**From:** Bloomer, David <David.Bloomer@lancashire.gov.uk>  
**Sent:** 18 May 2018 08:34  
**To:** Adam Birkett  
**Cc:** LHS Customer Service; planning  
**Subject:** app3/2018/0389 Moon Cottage Fleet Street Lane Ribchester

The proposal is outline for the erecting of a dwelling within the curtilage of Moon Cottage with all matters , including access, reserved. Within the design and access statement there is a suggested layout plan of the siting of the proposal showing the creation of a new access onto Fleet Street Lane to the south of the site. I would have concerns that the suggested location of the access would not benefit from the sight lines expected for a 60mph road . The site is bounded by third party land which be the subject of future sight line issues and a telegraph pole. My preference would be for the site to be have a shared access with Moon Cottage where the hedges bounding the site can be moved / removed as necessary.

1:500 Site Plan Proposed

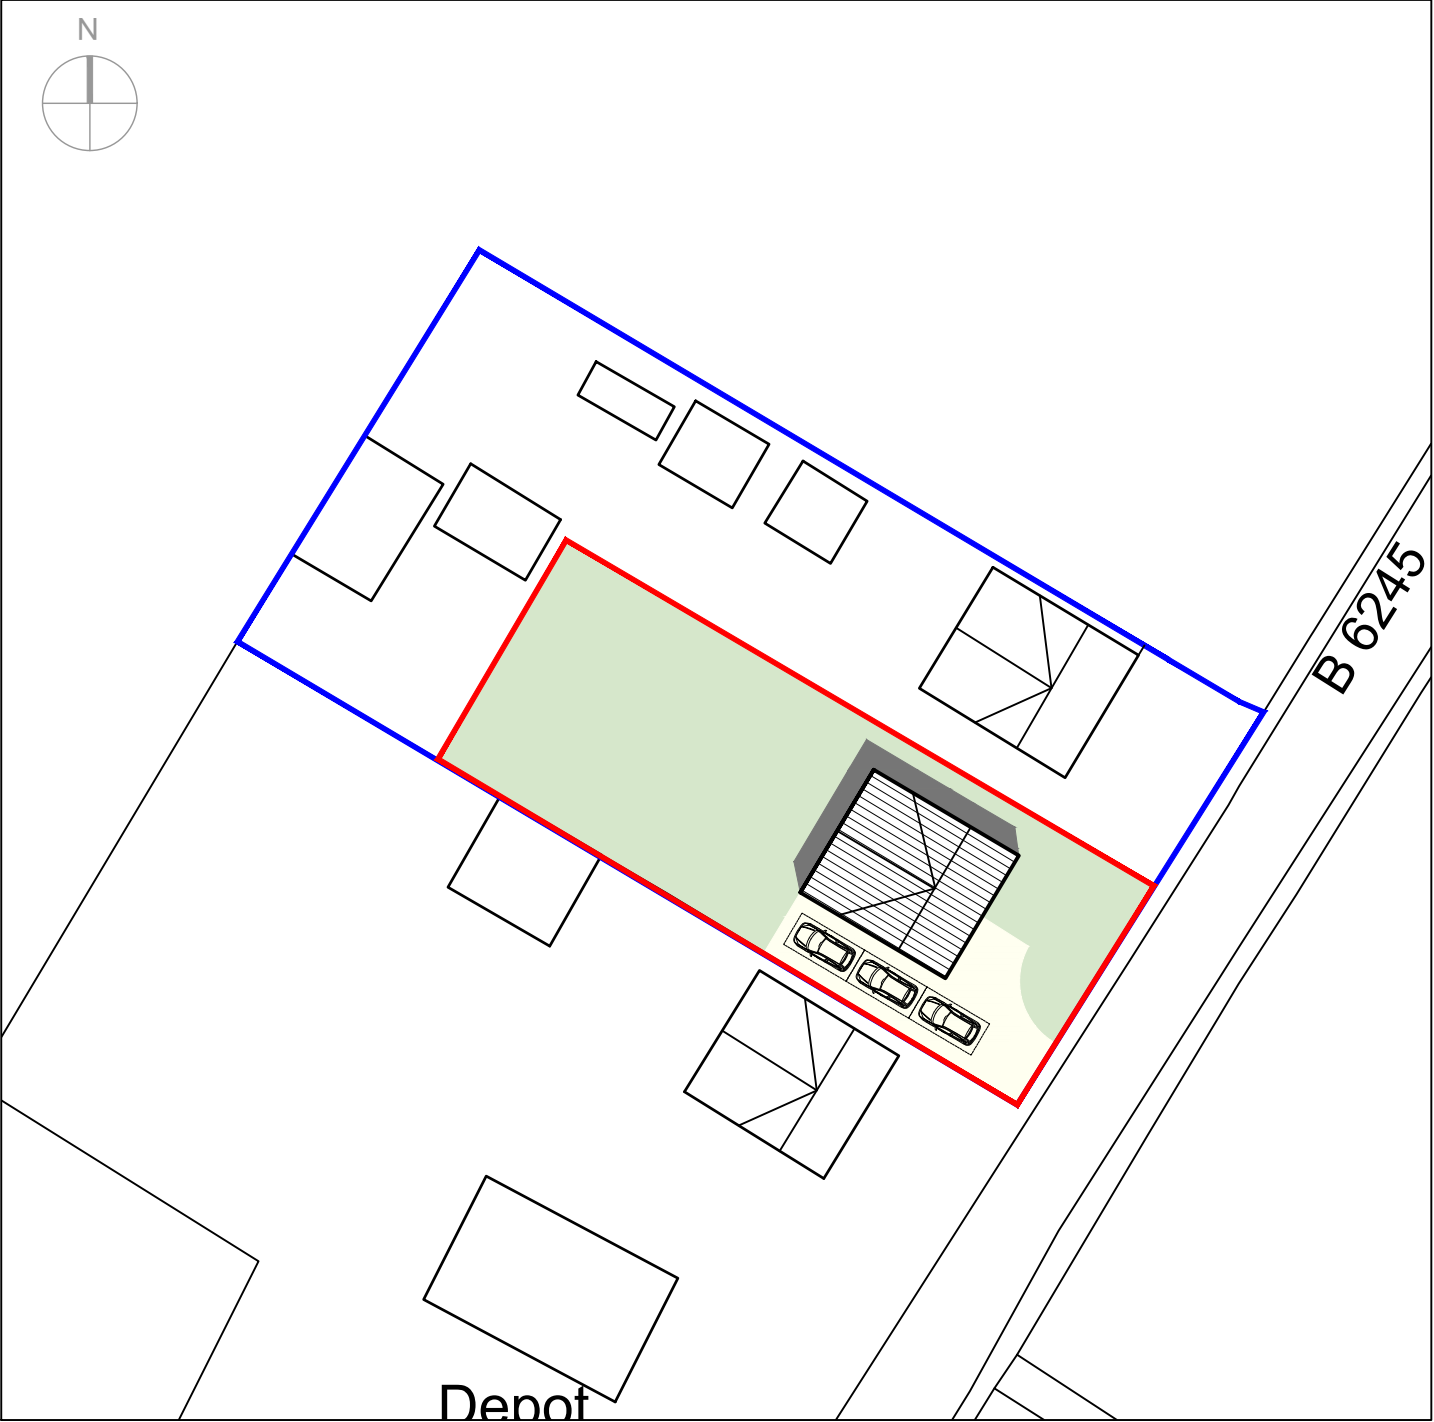
I also noted that tandem parking was shown for 3 vehicles. If this style was to be adopted in the final scheme then it would result in frequent reversing movements to / from the highway which would not be recommended . My preference would be for each of the necessary parking spaces to be accessed independently from within the site and facilities provided to enter / leave in forward gear.
